June 5, 2008

RE: SEPA Action McIntosh 1, 2, 3, - CUP-06-11, CUP-06-12, CUP-06-13

Thank you for the opportunity to comment on the proposed MDNS for the McIntosh CUP-06-12 proposed mine. There was insufficient information in the MDNS to determine if a Department of Natural Resources (DNR) Surface Mine Reclamation Permit will be required. If the extraction area is 2.99 acres and does not include areas disturbed by mine related activity as defined in RCW 78.44.031(5) then a permit will be required prior to the disturbed area reaching 3 acres. Disturbed areas are defined in law as:

POND
2.99 acres

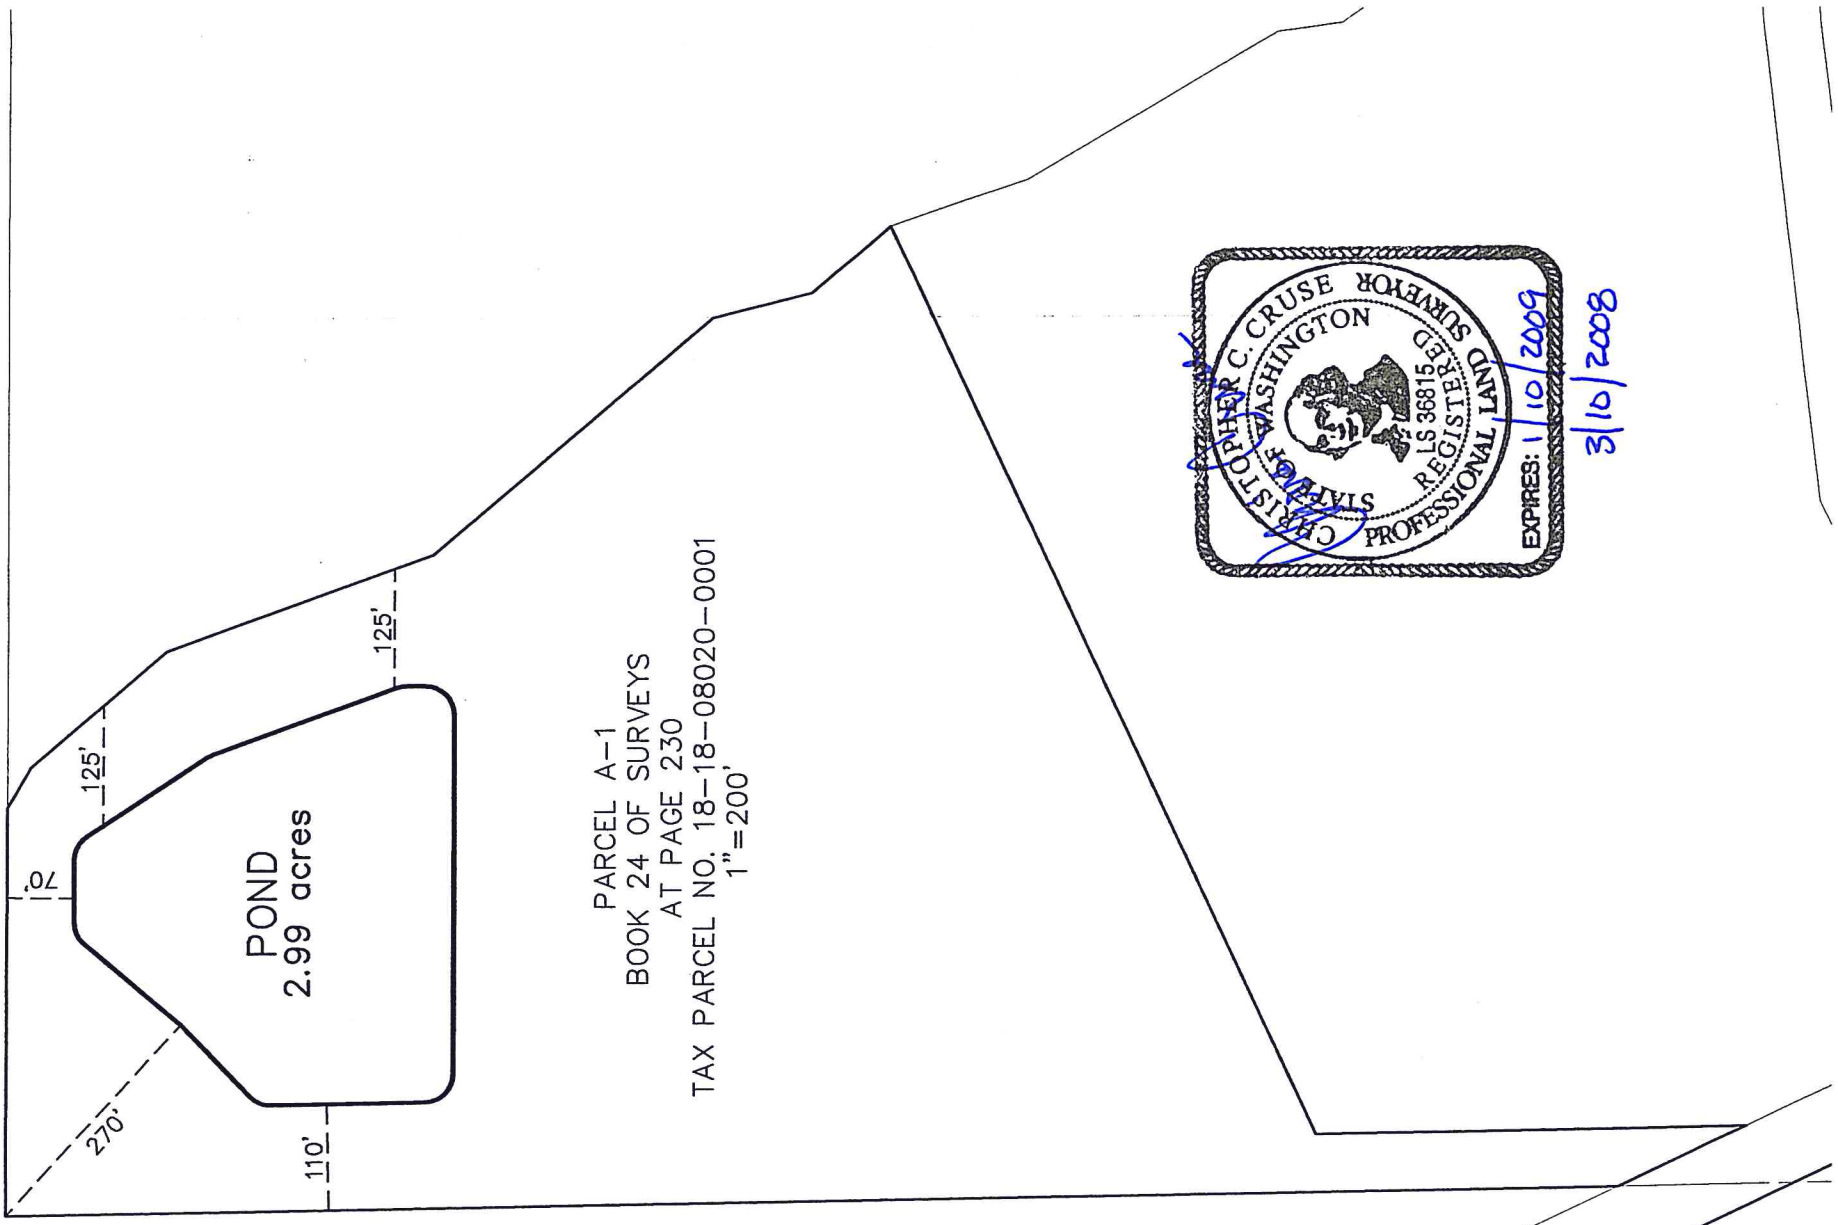
All areas that will be disturbed by placement of topsoil or other resource stockpiles and roads that will be reclaimed post mining would also be included in the disturbed area.
